Green Hill Solar Farm

EN010170

The Applicant's Responses to Local Impact Reports

Document Reference: EX4/GH8.1.26
The Infrastructure Planning (Examination Procedure) Rules 2010
Rules 8(1)(c)

Title:
Figure 8.1.5 Site Locations and Study Area
Green Hill G

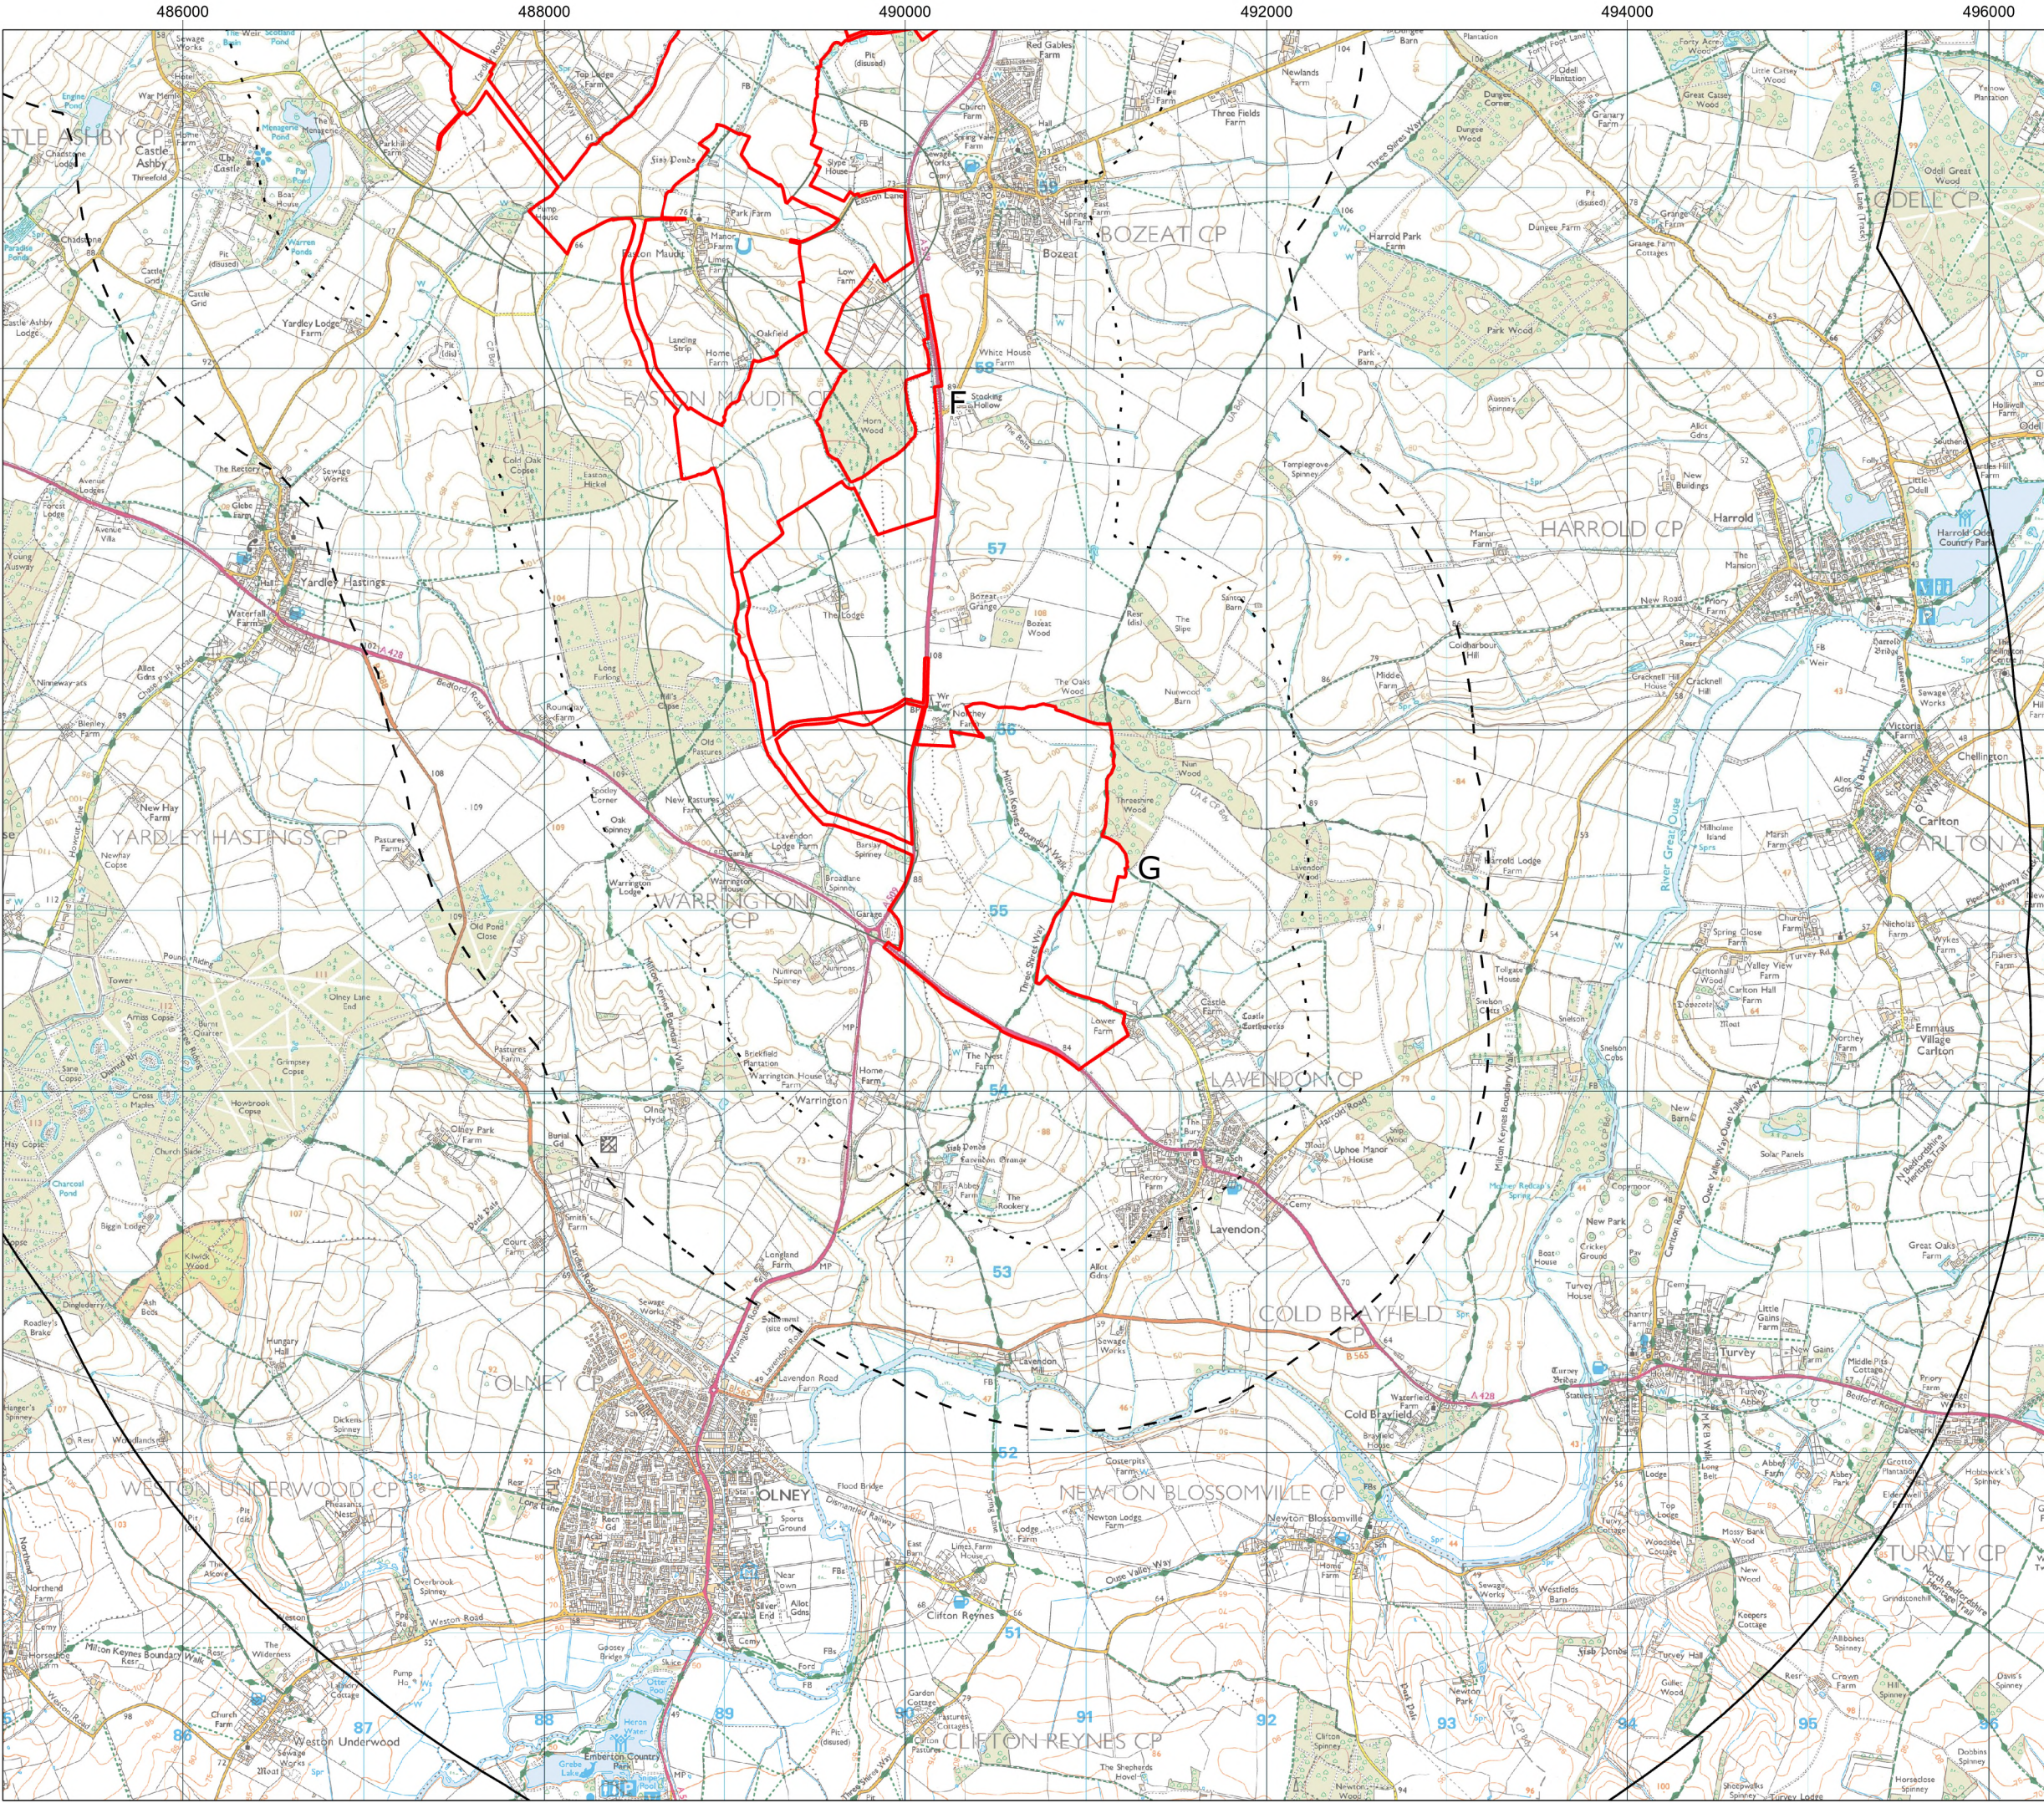
LIR Ref.	Topic Area	Summary	Applicant's Response
MKC 4.10- 4.11	Landscape and Visual Impact	Woodland belts are proposed to protect most views from the A509, but these are not included along the A428 and should be.	<p>Landscape mitigation alongside the A428 includes for '<i>Proposed Secondary Native Species Rich Hedgerow With Densely Spaced Native Hedgerow Trees</i>'. This comprises the planting of a new hedgerow adjacent to an existing hedgerow which would also be planted with new native trees. The management of the existing hedgerows would facilitate vertical growth, with the OLEMP [REP3-062] requiring that the shrubby element of hedgerows (excluding hedgerow trees) will be maintained to an optimum height of 4- 4.5m tall.</p> <p>The '<i>Secondary Native Species Rich Hedgerow With Densely Spaced Native Hedgerow Trees</i>' is proposed along the entirety of the Site G's southern boundary with the A428, and in combination to the management prescriptions of the existing hedgerow are considered appropriate to provide screening of the infrastructure within Site G for users of this busy section of highway.</p>

MKC 4.10- 4.11	Landscape and Visual Impact	There are clear views available along the A428 south of the pylons which intersect parcel GF13 along the southern-most section of road / solar development and at the southernmost corner of the parcel. The viewpoint VP53 is selective in that it does not identify the location where there is a stretch of clear views into the site from the A428. Mitigation here should be bolstered by the inclusion of Proposed Native Woodland Copse/Shelter Belt (Scrub and Tree Planting) in this portion of the site; instead of the proposed hedgerow. Where the Bridleway 015 crosses the A428 additional woodland buffer is needed here to screen the development.	The Applicant notes this comment, however, is confident that the planting as proposed is suitable to mitigate visual effects associated with users of the A428 to the south of Site G.

LIR Ref.	Topic Area	Summary	Applicant's Response
MKC 4.10-4.11	Landscape and Visual Impact	<p>There are clear views available along the A428 along the edge of parcels GF10 and GF12 during winter in particular and due to the rising topography of the site towards the north. The viewpoint VP40 demonstrates the rising topography and vegetation in full leaf. A hedgerow is already proposed in addition to the existing hedgerow. However, mitigation here should be bolstered by the inclusion of Proposed Native Woodland Copse/Shelter Belt (Scrub and Tree Planting) in this portion of the site; to achieve more effective mitigation.</p>	<p>The Applicant notes this comment, however, is confident that the planting as proposed is suitable to mitigate visual effects associated with users of the A428 to the south of Site G.</p>
MKC 4.10-4.11	Landscape and Visual Impact	<p>Although views from the Milton Keynes Boundary Walk (MKBW) looking eastwards are largely screened by the inclusion of woodland buffer there are less well screened views westwards from the MKBW across the solar development where the associated infrastructure has the potential to be visually obtrusive. Such as but not exclusively from viewpoint VP36. Photomontages indicate that the Proposed Substation will not be visible due to the scale of solar development in the foreground. Only Proposed River Corridor Planting for flooding is proposed along the westside of the MKBW. Unlike woodland or hedgerow this will not offer sufficient visual mitigation. Also, we note that the Proposed River Corridor Planting for Flooding for Site G is not listed in the OLEMP unlike the other sites.</p>	<p>The '<i>Proposed River Corridor Planting For Flooding</i>' along the eastern side of the ditch which runs alongside the MKBW is intended to provide reinforcement to the existing tree belt in this location with the planting consisting of densely planted native riparian shrub.</p> <p>Planting for Site G is acknowledged in paragraph 4.5.3 and in the total areas of habitat covered by paragraph 4.5.5.</p>

Title:
Figure 13.5 (Rev A): HGV Routes to Scheme
(South Area)

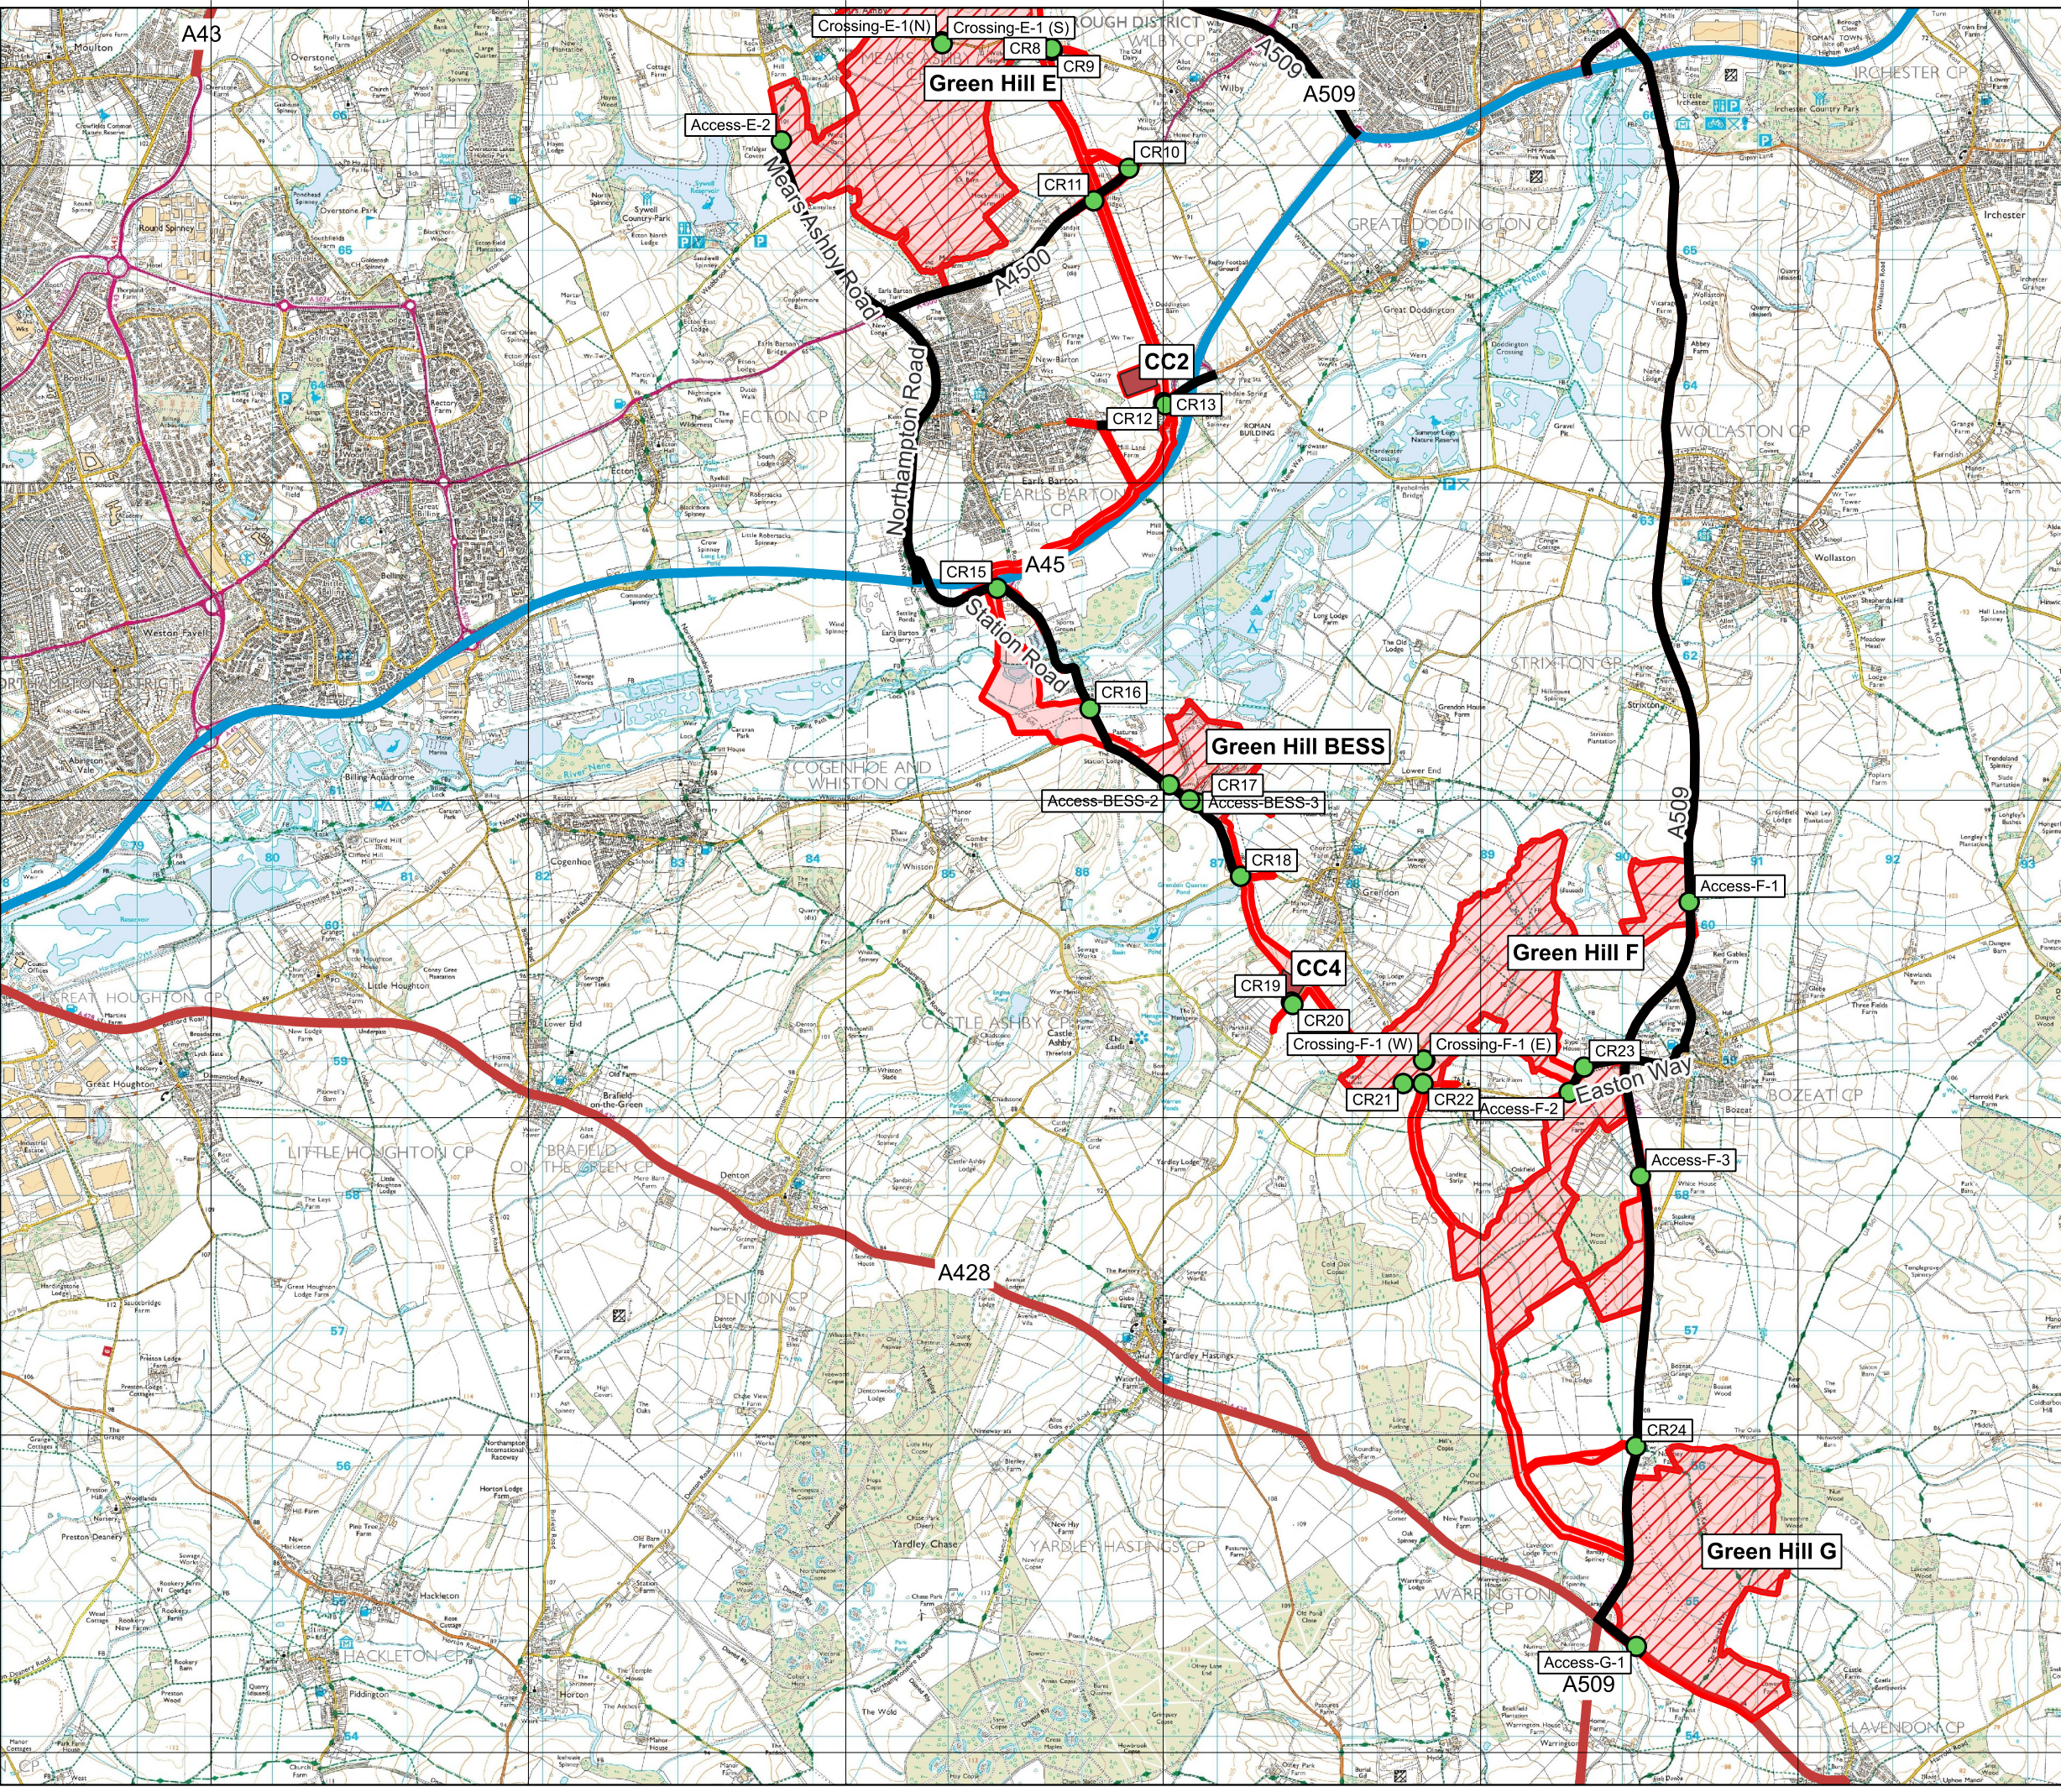
MKC 4.37 – 4.42	Transport and Access	<p>Following comments on the access to site G the applicant has submitted revised tracking drawings to be consistent with the proposed HGV routes.</p> <p>However, this still shows an HGV entering the site would have to use the full access width so would have to wait on the main carriageway if a vehicle was leaving the site. The applicant proposes to address this by a banksman controlling when a vehicle can exit to reduce the possibility of a conflict but this appears a little arbitrary and the Council would prefer the access to be widened as previously requested.</p>	<p>A revised drawing showing how a vehicle may access and egress the site at the same time has been prepared to address the comment raised by MKCC. Please see Green Hill G - Access 1 - Revised General Arrangement [EX4/GH8.2.10].</p>
MKC 4.37 – 4.42	Transport and Access	The applicant has now provided vehicle numbers for the cable route corridor access on the A509. These would be 11 arrivals per day during the haul road	The vehicle movements figures provided are the peak or maximum daily numbers which might occur. Movements at other times within this construction period will be

LIR Ref.	Topic Area	Summary	Applicant's Response
		construction period although it is noted not all would be articulated vehicles. This number, whilst not excessive is not insignificant as it represents 22 movements 2 way. The Council would therefore request an estimate of the haul road construction period before making a final comment.	expected to be lower. Movements are also spread across the day rather than compressed into arrival and departure periods. The access is also expected to operate as a left-in / left-out arrangement, minimising turning movements on the A509 by removing opportunity for right turn movements across traffic. The access will be available for the majority of the construction period but with varying degrees of usage as described above.
MKC 4.43 – 4.45	Transport and Access	Additional information has now been submitted giving more detail on shuttle buses and control of travel times. The points raised in this section are therefore considered to be addressed and it is accepted the level of traffic generation within the Milton Keynes area is not excessive.	The agreement in relation to traffic generation is noted.
